May 22, 2013

RE: Wickham Short Plat SP-13-00002

Thank you for the opportunity to comment on the Wickham Short Plat, SP-13-00002.

WICKHAM SHORT PLAT
PART OF SECTION 33, T. 18 N., R. 19 E., W.M.
KITITAS COUNTY, WASHINGTON

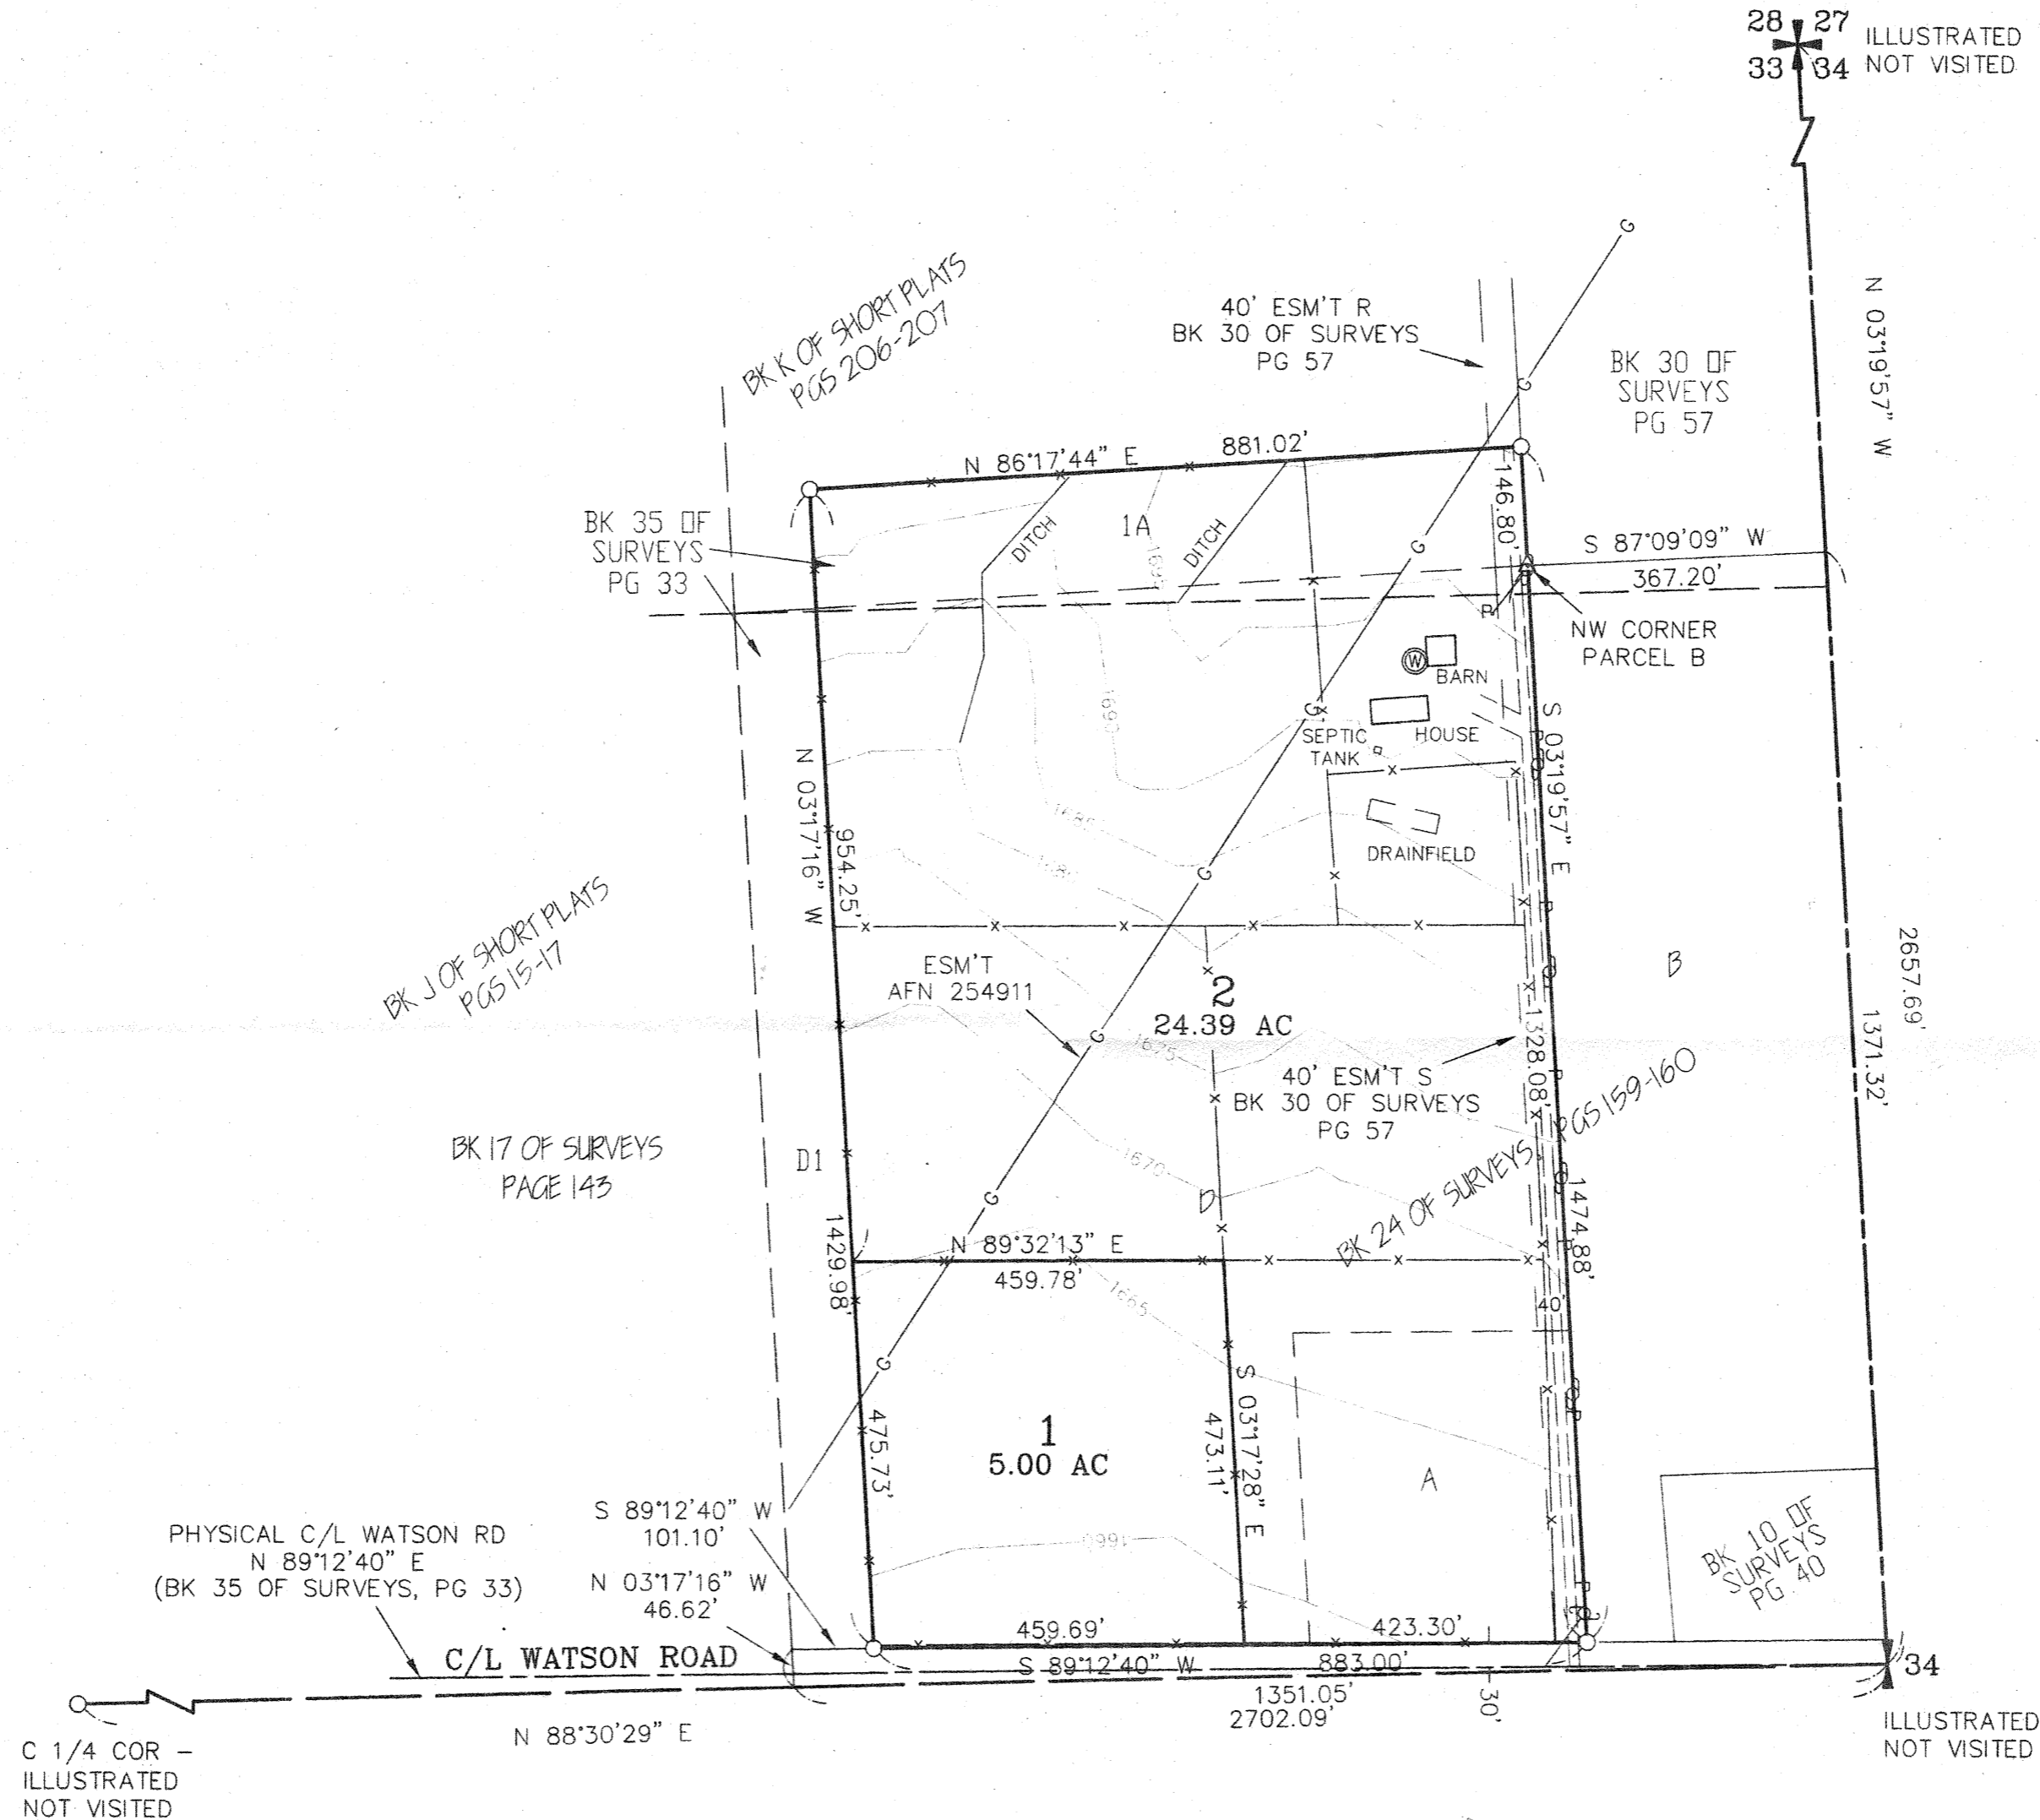
Since the proposed lot 2 already has a permitted septic system that lot will not require a soil log, you will only need to provide a soil log on the larger lot 1 located at your discretion as long as it makes 100' soil

setbacks from surface water. It appears that there is a well located on lot 2, you will either need to drill a well on lot 1 or provide a recorded shared well users agreement supplying lot 1 from a well on lot 2. The above mentioned requirements need to be satisfied and the appropriate documentation needs to be submitted to KCPHD for review and approval in order for the plat application to be recommended for final approval.
